File: EF14/ 23309  
Job ID No: DOC15/333736  
Your Ref: SSD 6611

**RE: Request for Heritage Council Comment – Cockle Bay Marine Structures Renewal State Significant Development (SSD6611)**

Cockle Bay Marine Structures
Developed Design
General Arrangement Plan

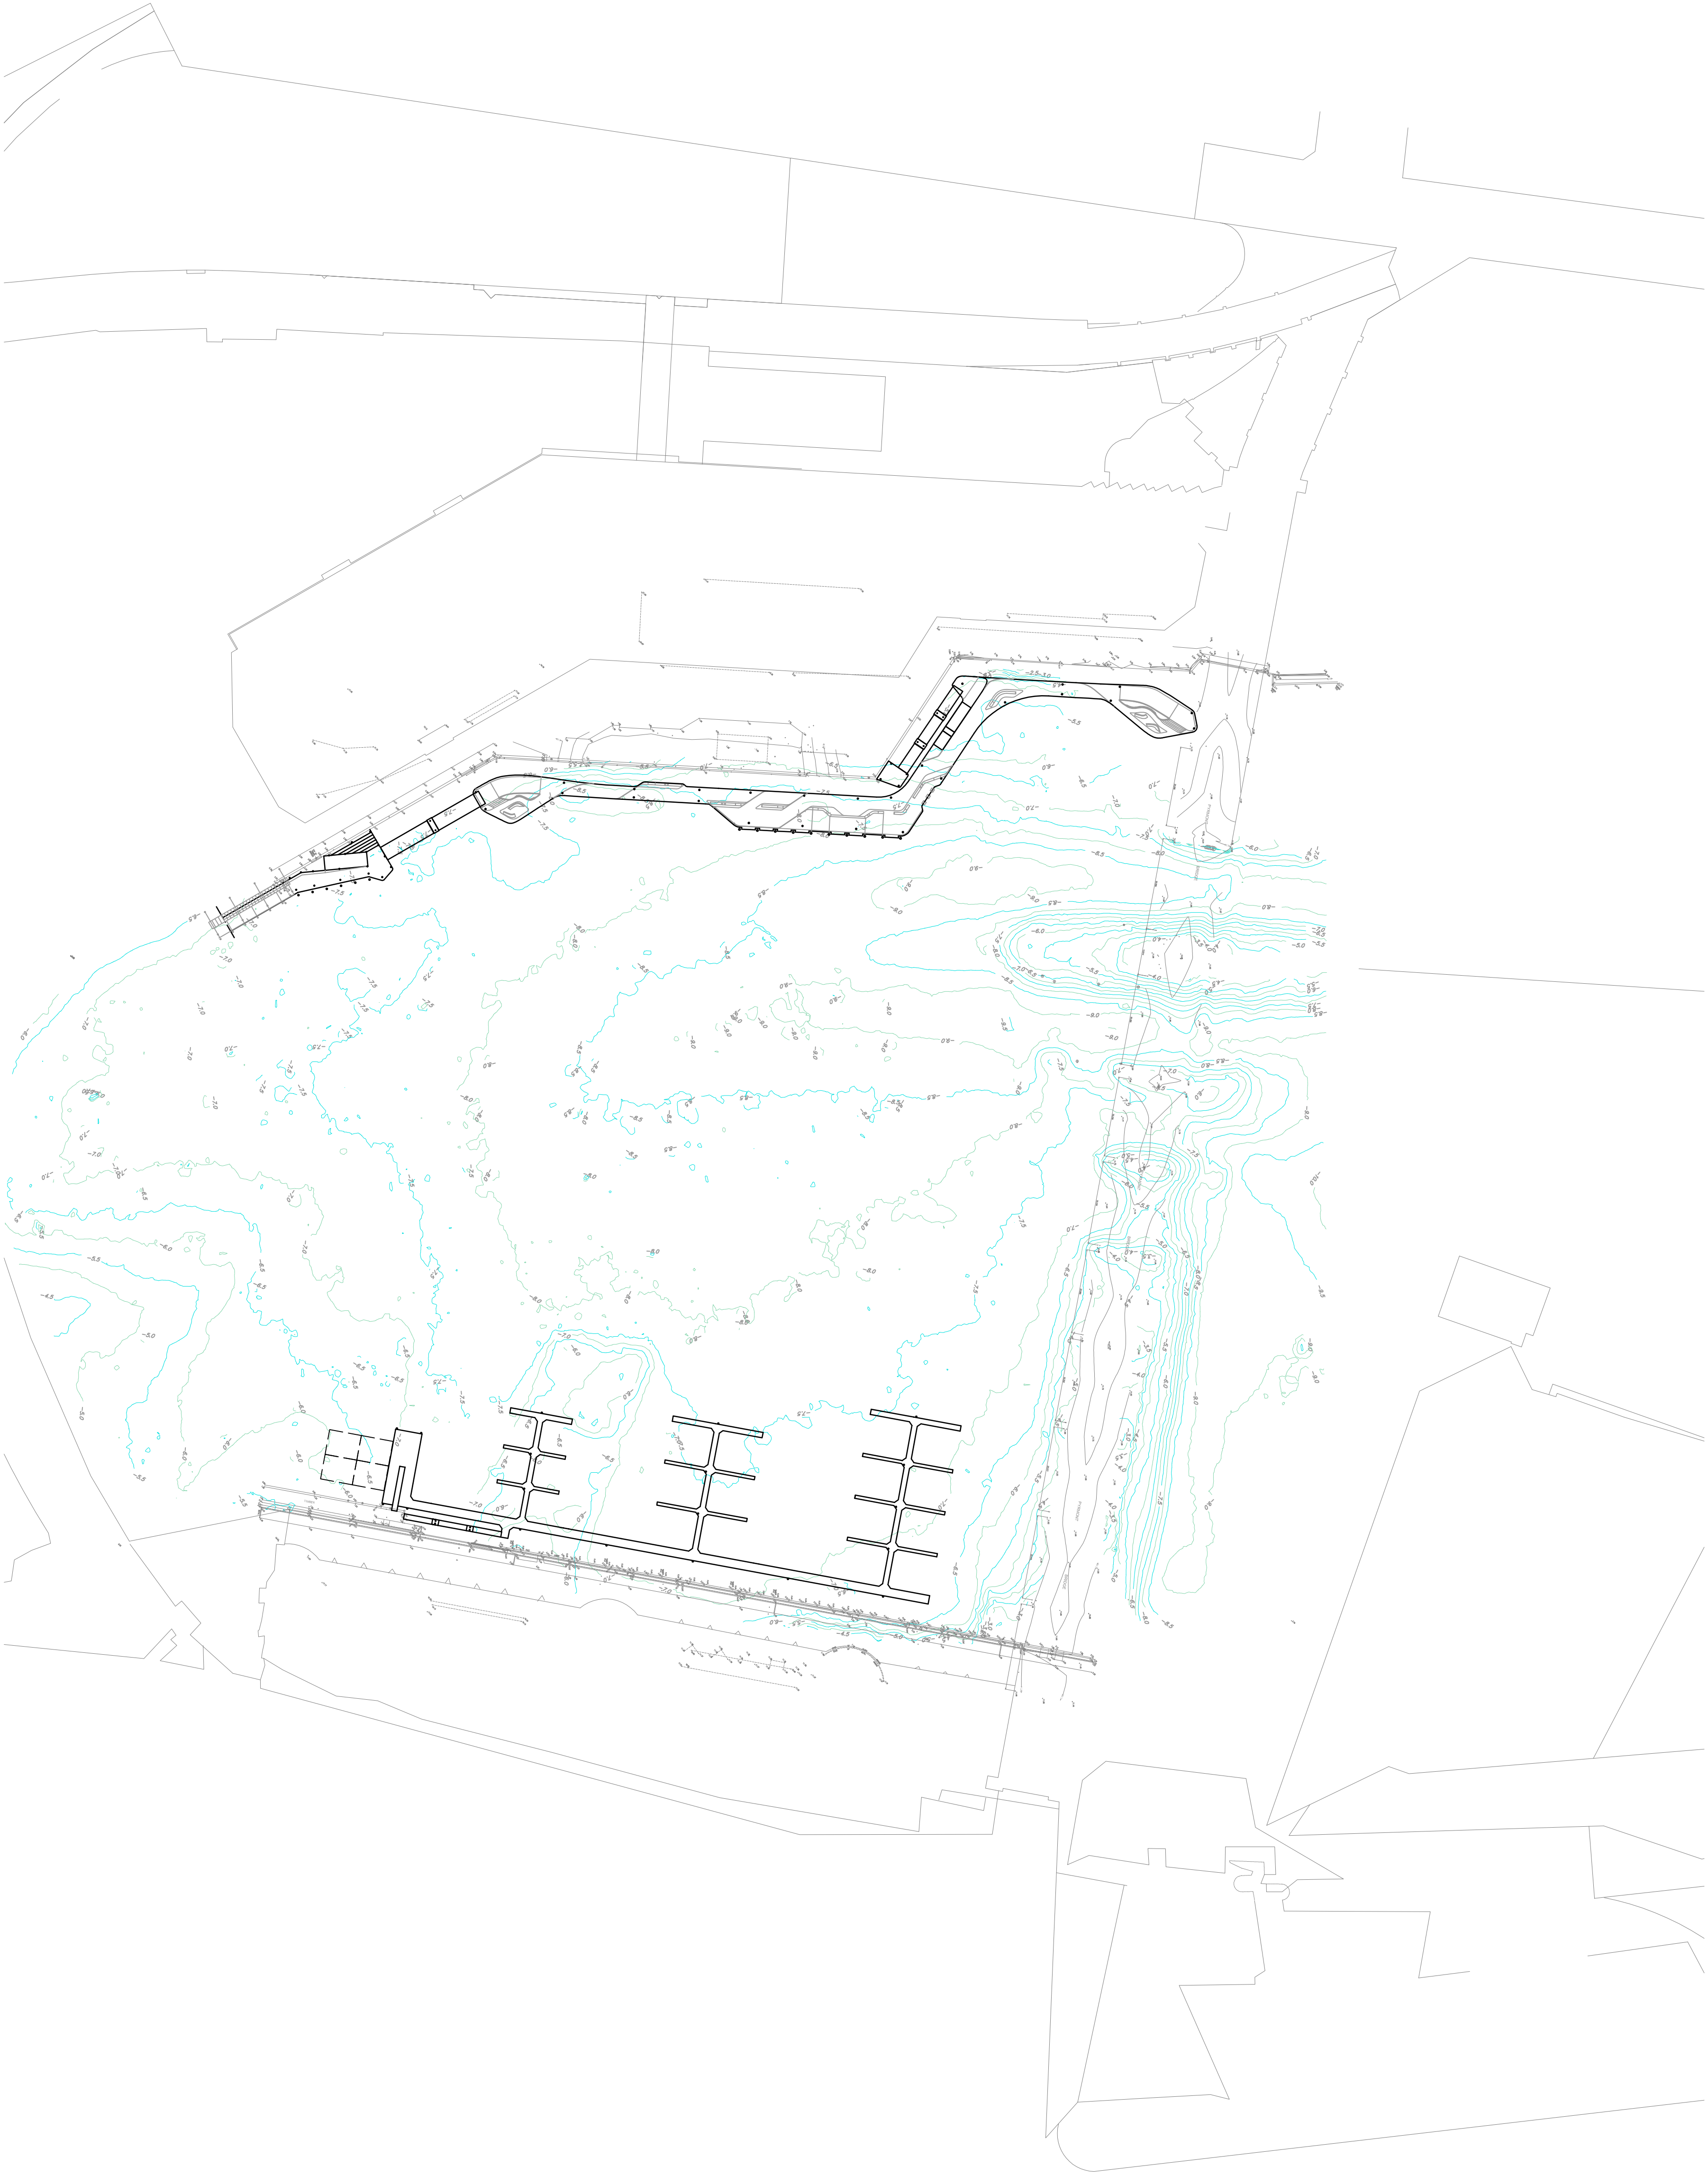
8.11.3). Physical remains evidence in the survey only identified modern debris and high sediment content. The MAS&SOHI and the EIS did not provide a specific assessment of the effects of the proposed piling on these phases of occupation or their likely significance. The EIS needs to compare the known phases of occupation and relics against the proposed piling locations in order to assess any likely impacts.

- The MAS&SOHI and EIS have not considered the impact of this proposal on the state significant archaeology. The proposal has stated that the piling will cause harm to state significant archaeology within the seabed. On this basis, it is recommended that any impact should be minimised as much as possible through a careful consideration of the pile design in this area. The mitigation of the loss of state significant archeology should be clearly outlined in the EIS prior to any approval of the SSD by the DPE. It is recommended that upon receipt, DPE refer this additional information to the Heritage Council for consideration of its adequacy and to advise DPE of any additional conditions of approval that may be appropriate.
